NOTICE OF VIOLATION

RE: 20 Sawyer Street-138-B006

An evaluation of your property at 20 Sawyer Street on 10/12/04 revealed that the structure fails to comply with Section 104.40 of the Building Code of the City of Portland.

Foundation Plan

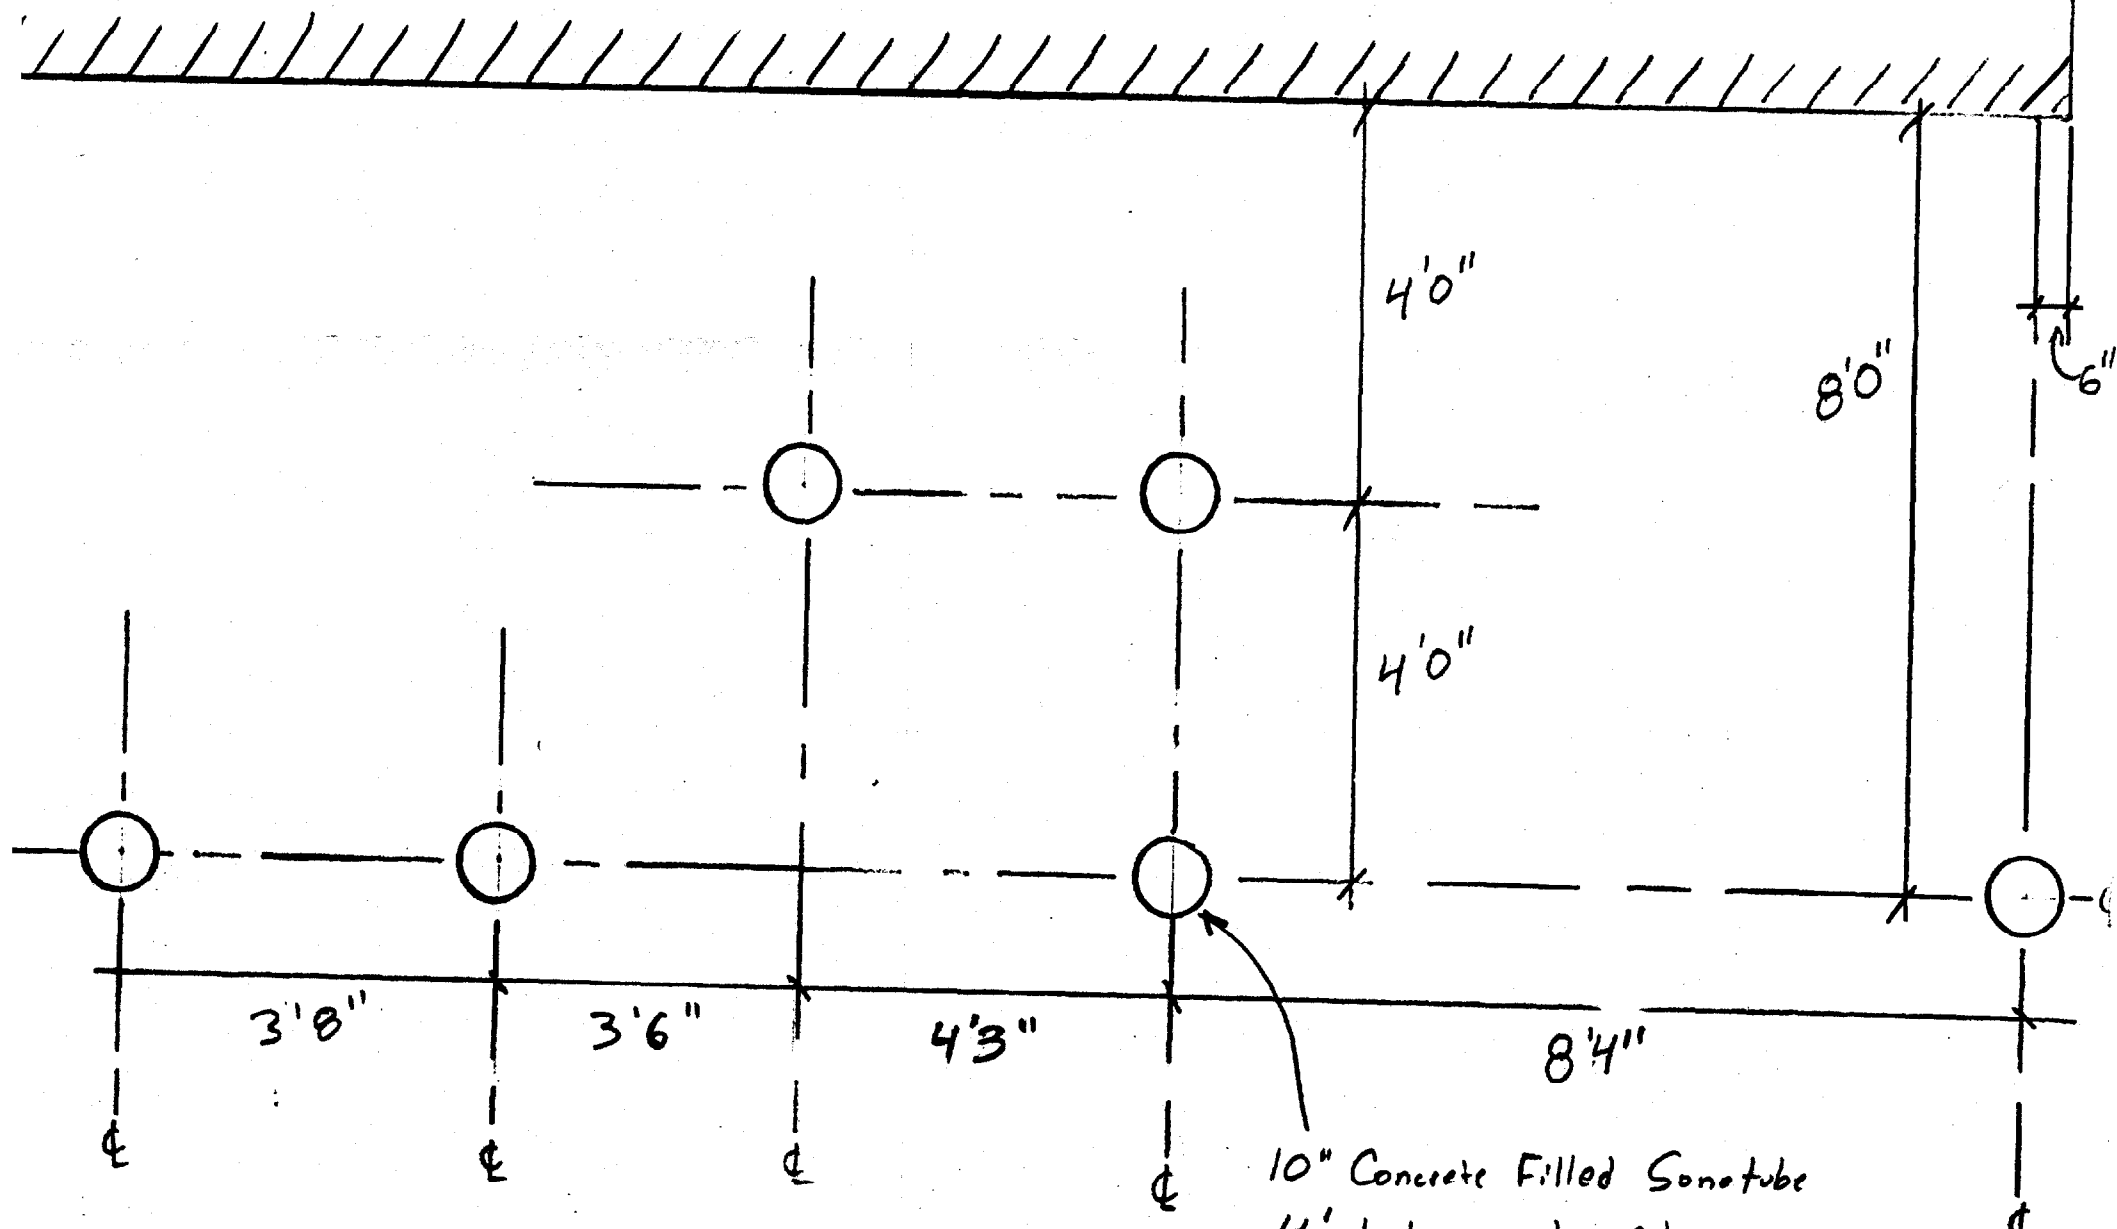
1. Unable to determine required Sono tube depth of 48" due to required inspection not being scheduled by contractor before pouring concrete.
2. No fasteners where Sono tubes meet concrete.
3. Stairs from 2nd to first floor rest on existing (old) porch which is not shown on plans, and the support is questionable.
4. Gusset plates only on one side.
5. Handrails are not returned on ends.
6. 3rd floor joist (left rear) not doubled and only resting on part (1") of 4x4 support.
7. Guardrails must all be at 42", as shown on submitted plans.
8. Open risers partially closed in by improperly attached strapping. Must be closed properly.
9. Treads and risers must be uniform as shown on plans. They vary from 7.75" to 8.75".
10. Stringers are split in several locations.
11. Stairs from 1st to 2nd are an 18'6" run and must be secured to prevent swaying.
12. Hangers missing nails (check all).
